DECISION DELEGATED TO DEVELOPMENT MANAGER

Application No: H11-1007-19 **Applicant:** Mr R White
Proposal: Caravan park reception/office and manager's house
Location: Vicarage Lane Long Sutton Spalding
Terminal Date: 5th June 2020

Drawings Title:
Plans, Elevations & Section

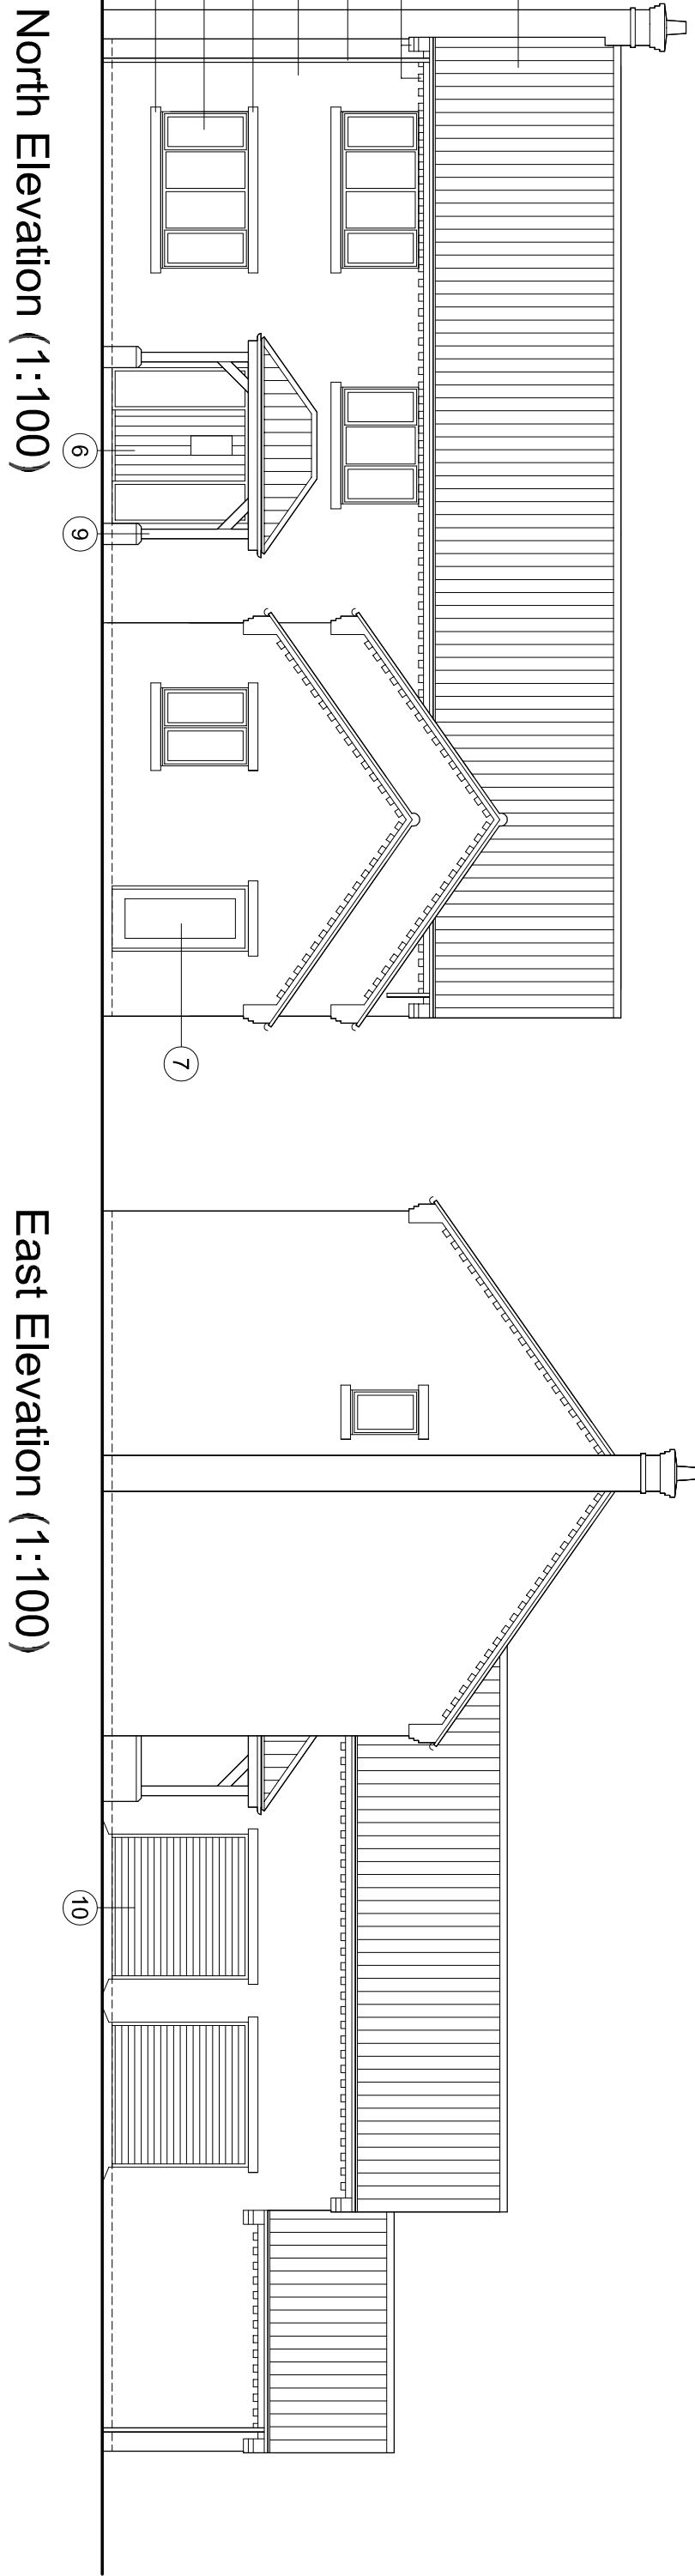
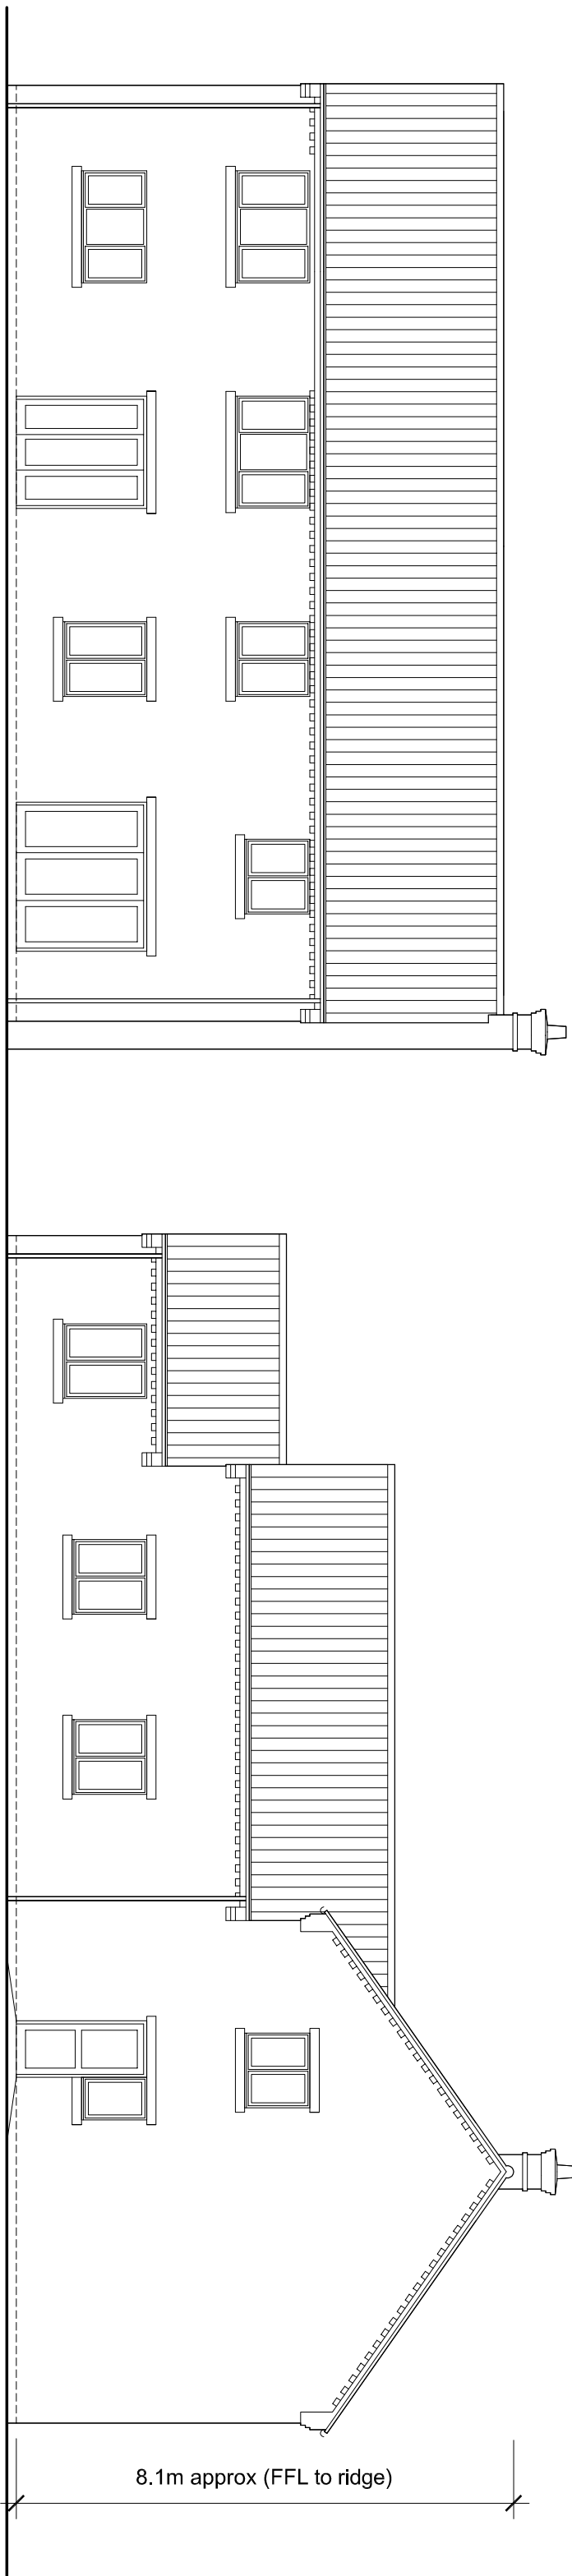
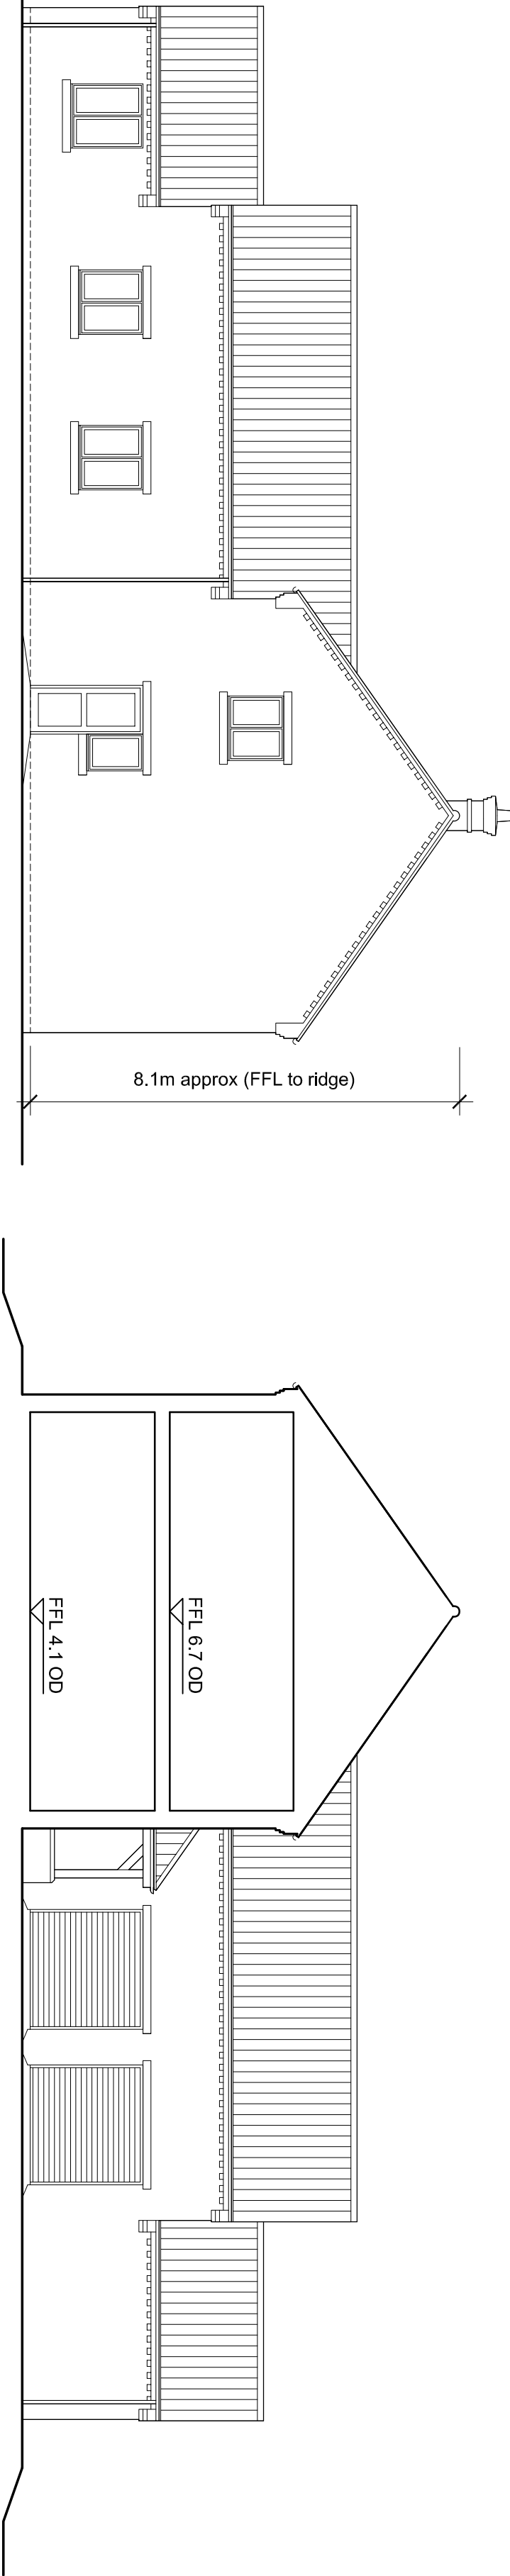
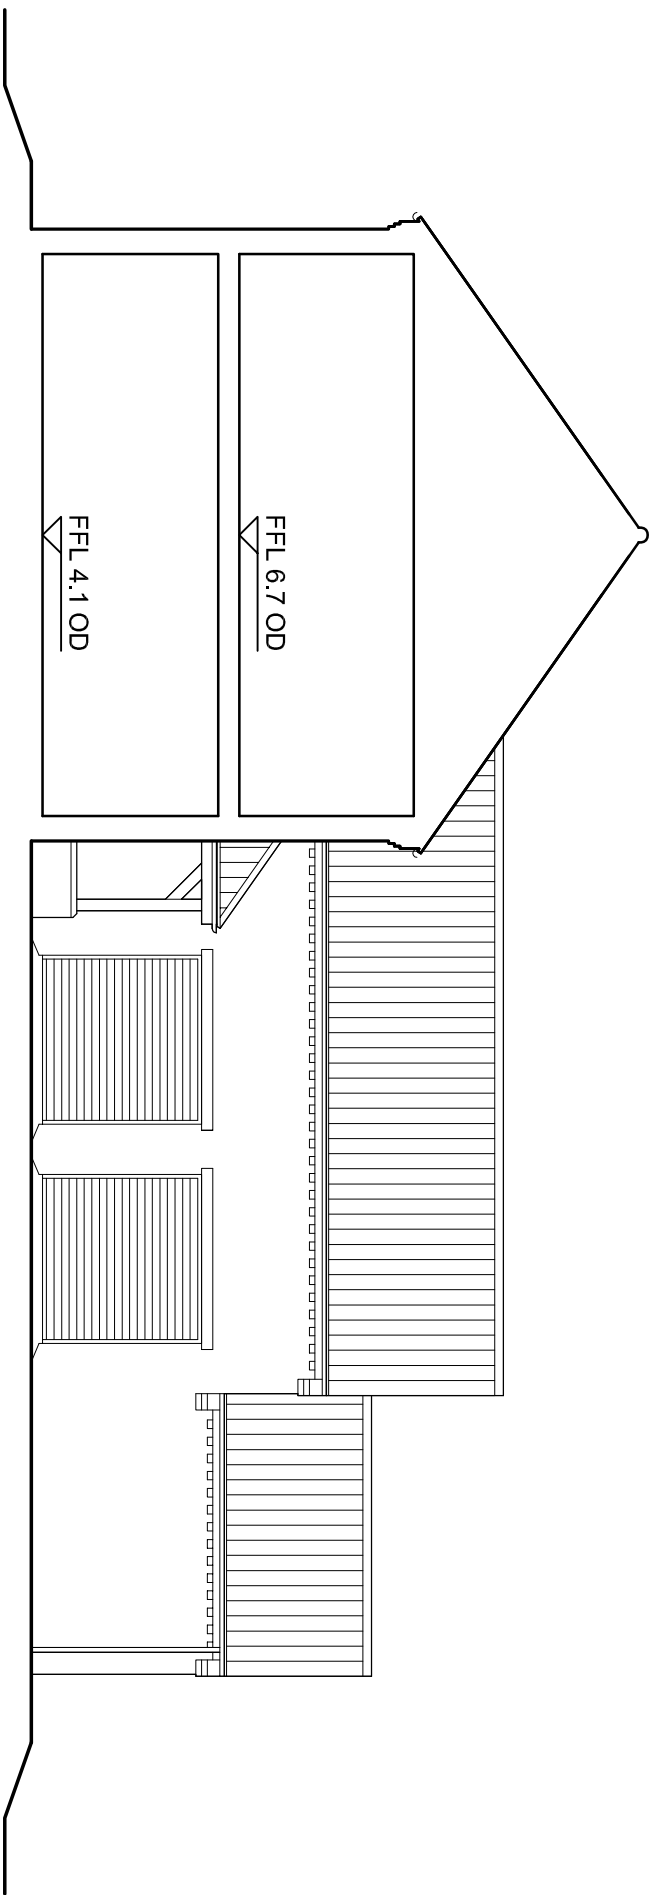
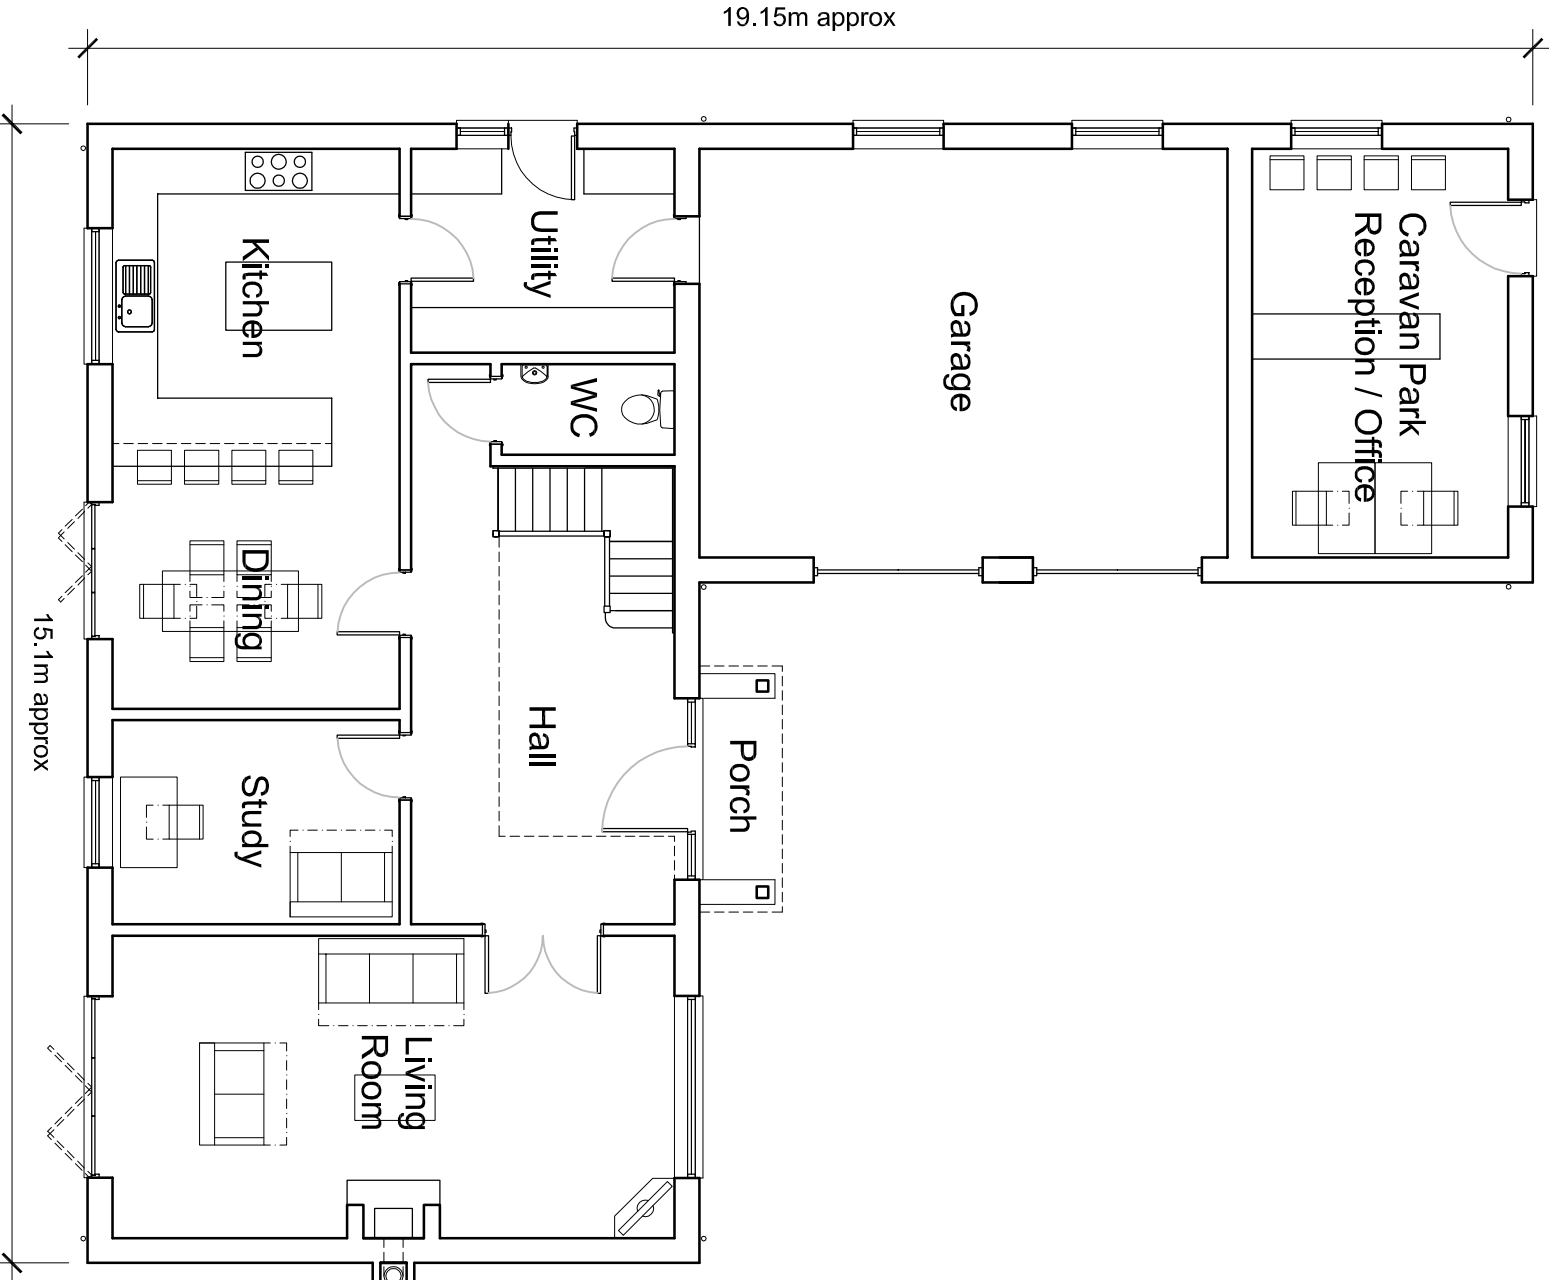
The footprint of the development shows that the property will have a L shape. The building will measure approximately at maximum 19.15 metres in depth, 15.1 metres in width and 8 metres in apex height. The eaves will be 4.75 metres high. The resulting scale and height will be significant excessive in view of a few low buildings in the area, The Hamber (west) and No. 59 (east).

From the front wall, the most protruding part will be a single-storey high pitched element but still subservient to the ridgeline of the house. It will accommodate the caravan park reception and office as well as double garage for the dwelling occupiers. Communal spaces will be located on the ground floor whereas 4 no. bedrooms will be on the first-floor level.

In summary, the material schedule and detailing is acceptable but the building will constitute an intrusive element that would be detrimental to the prevailing rural character of the countryside. The development will be excessive in relation to the few existing buildings in the locality by reason of scale and height. The proposals therefore are contrary to the aforementioned policies about design, layout and character of the local area.
